**RE: Stack Short Plat
SP-22006 – Third Submittal**

Please refer to our responses below which address all review comments received from the City of Marysville on January 18th, 2023, regarding the Stack Short Plat submittal package. You will find the markup comments listed in the order that they were written followed by our response in *italics*.

STACK DESIGN & CONSTRUCTION, LLC
STACK SHORT PLAT
 PRELIMINARY ROAD, GRADING AND STORM DRAINAGE PLAN

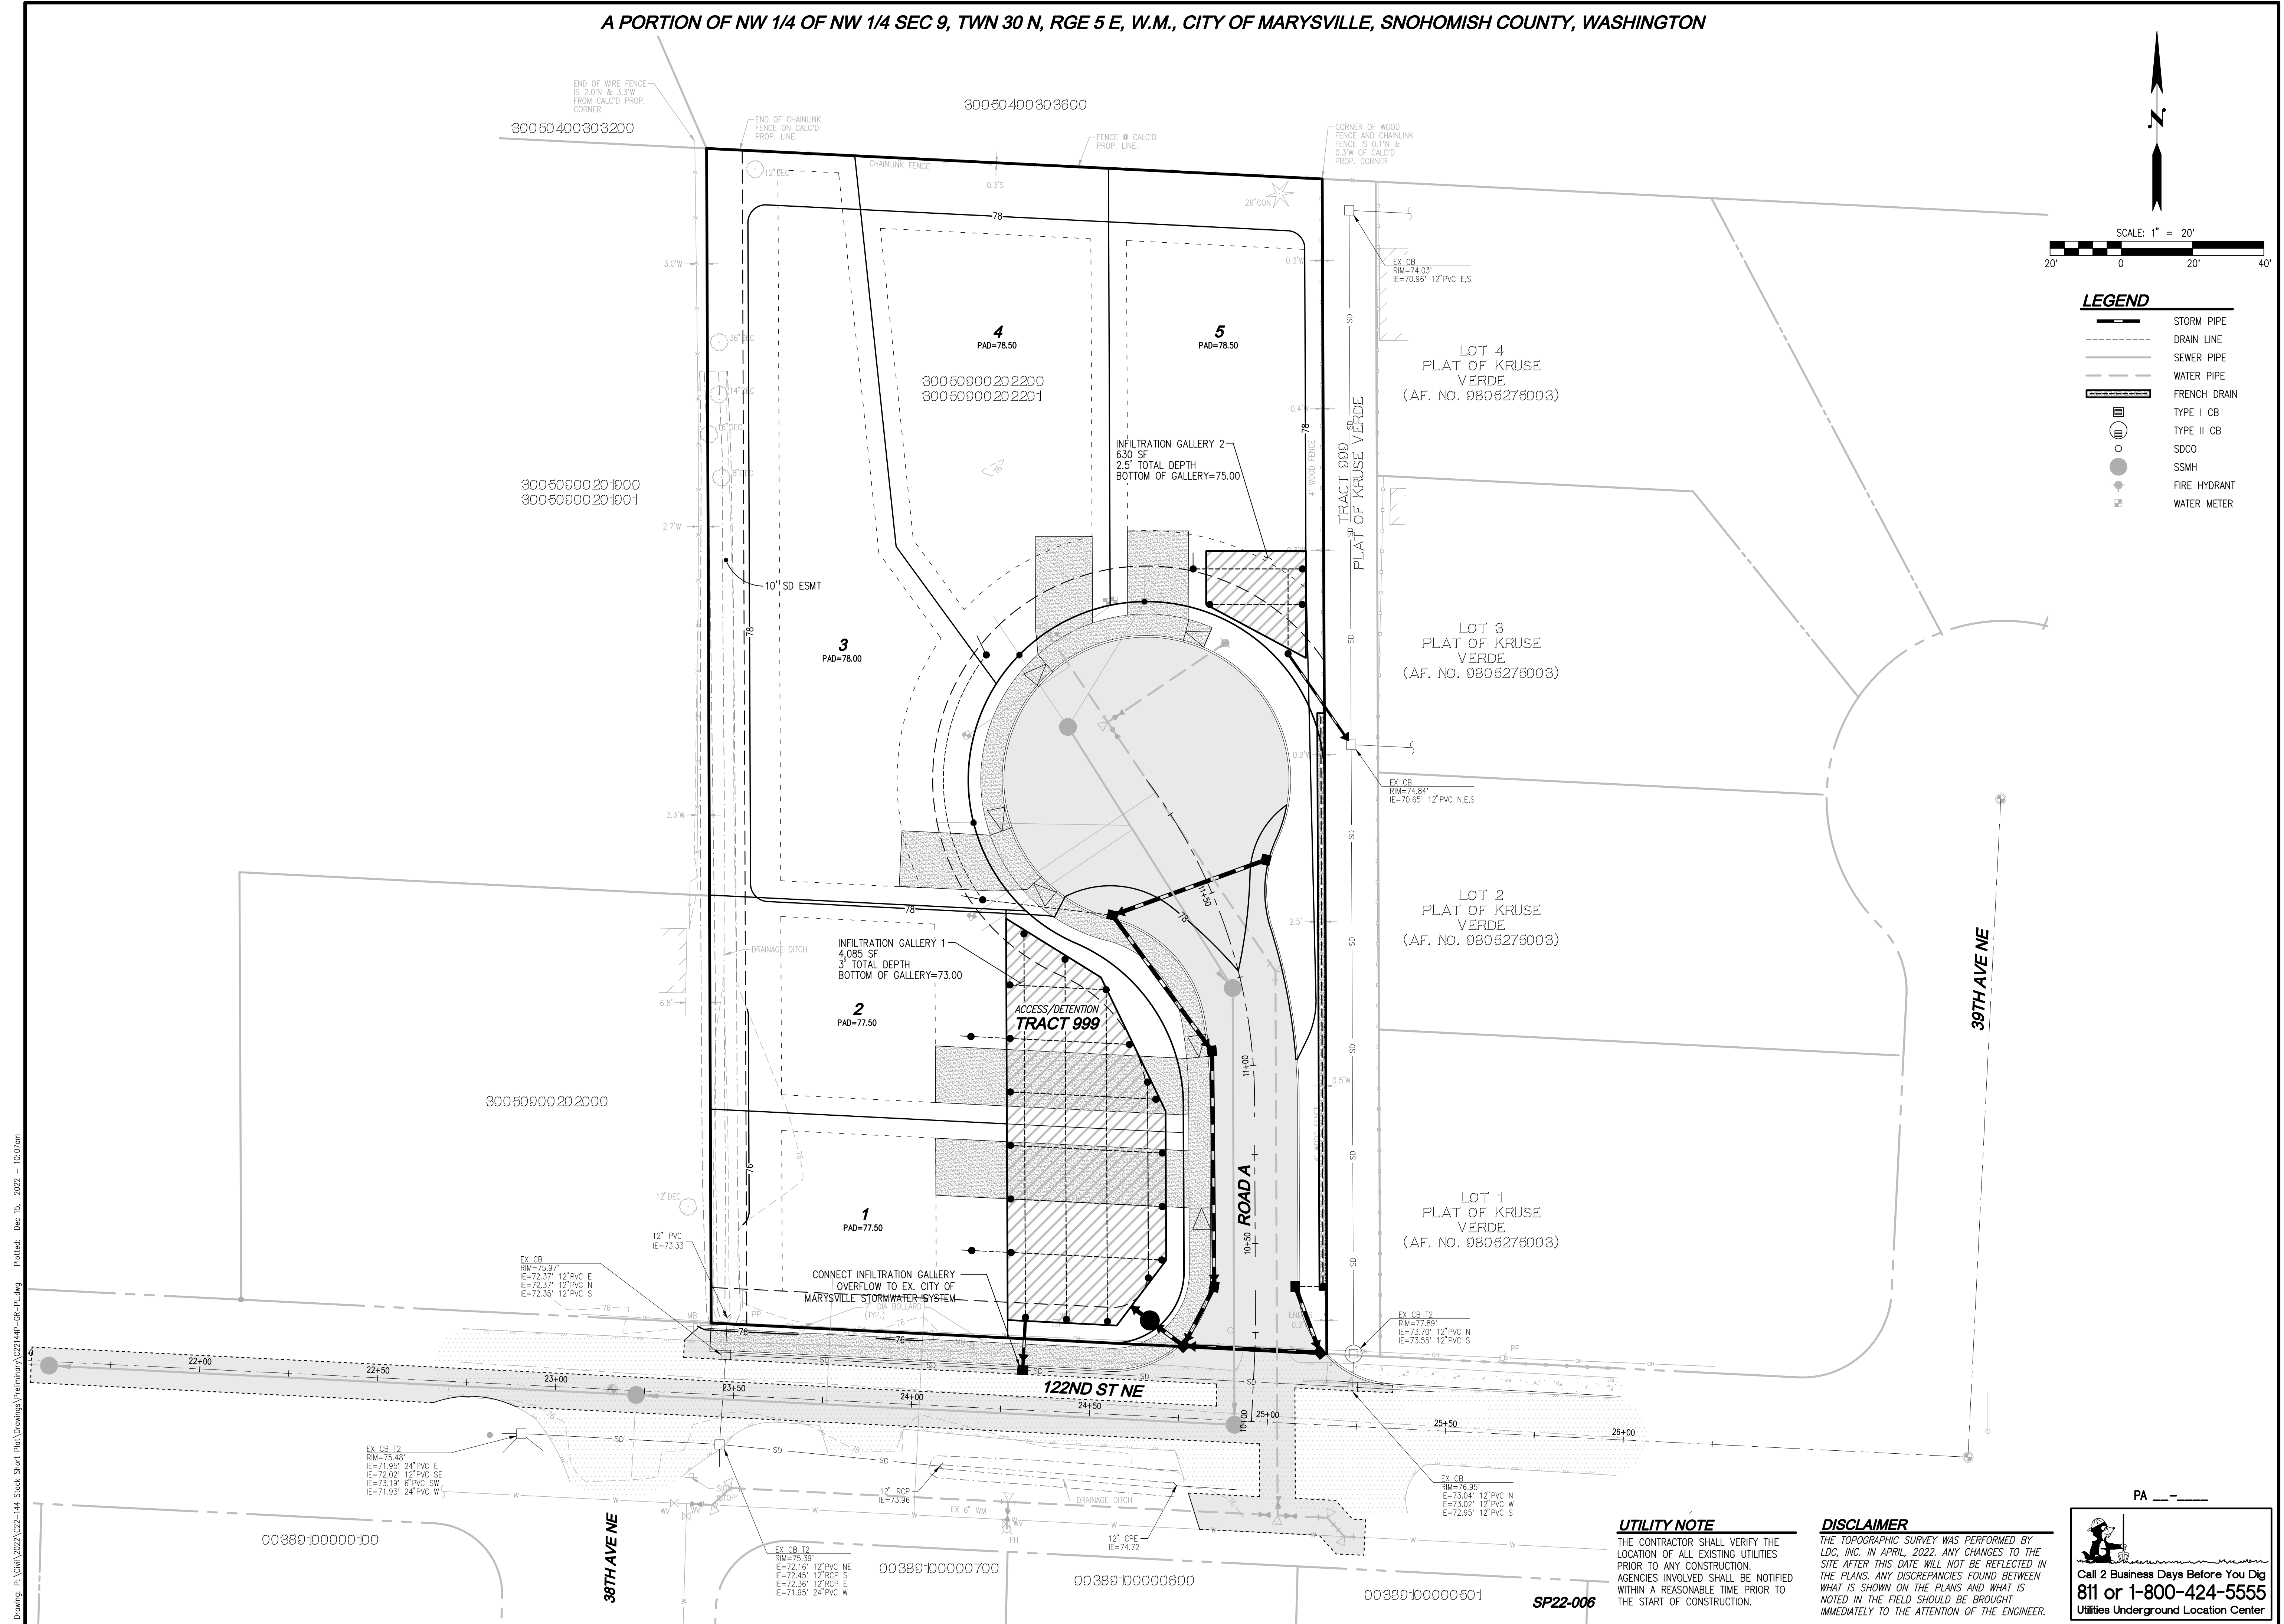
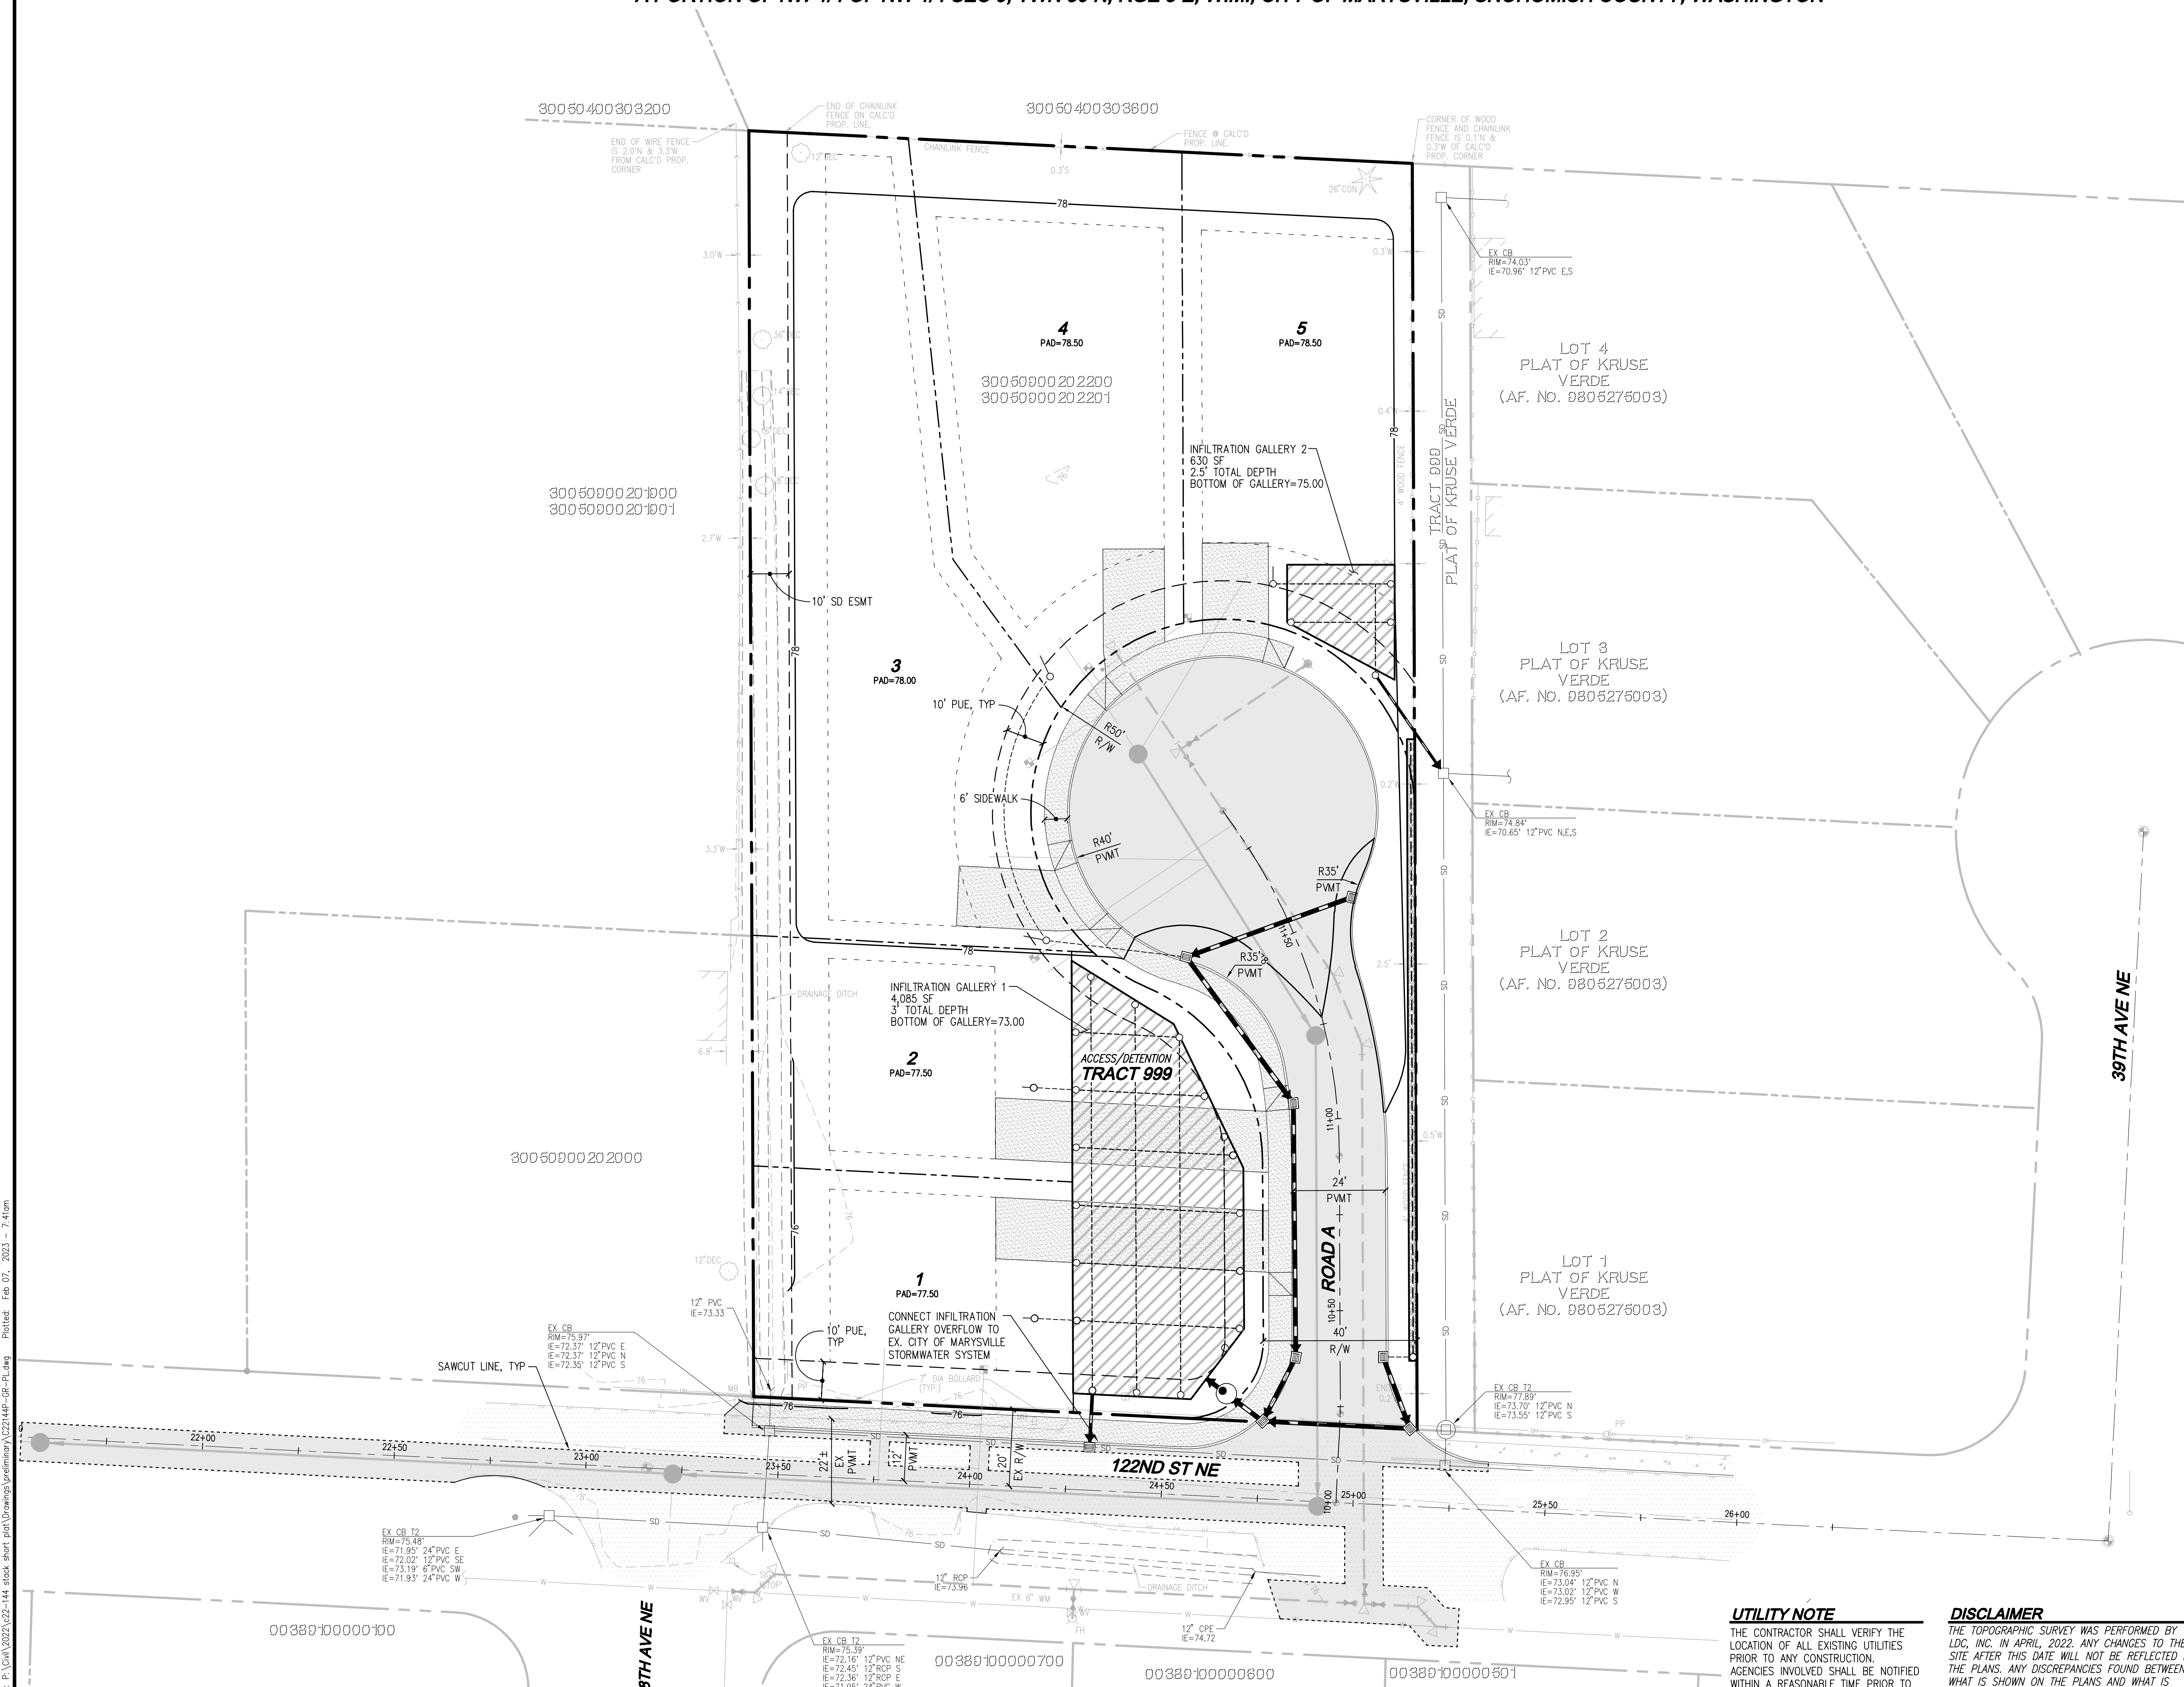
1. Please clarify about the separation of the infiltration facilities from the groundwater table. In what has been provided, it seems that there will not be the minimum 3 feet of separation from the bottom of the facilities. The mounding analysis states that the facilities will function with only 2 feet of separation, however the minimum standard is 3.

1. This design is not ideal. The private driveways will be utilized for parking. The cars and private use of the property will limit the City's ability to inspect and maintain the facility. I would rather see the facility in an area that is not encumbered by private property uses.

- Infiltration facilities that receive water from pollution generating surfaces are required to have pretreatment.

Response: Due to the conditions on site only 2 feet can be provided. A mounding analysis was provided to show that the facility will function.

Response: Per conversations with the city this is the only feasible location for the facility.

Response: This will be shown on the construction plans.
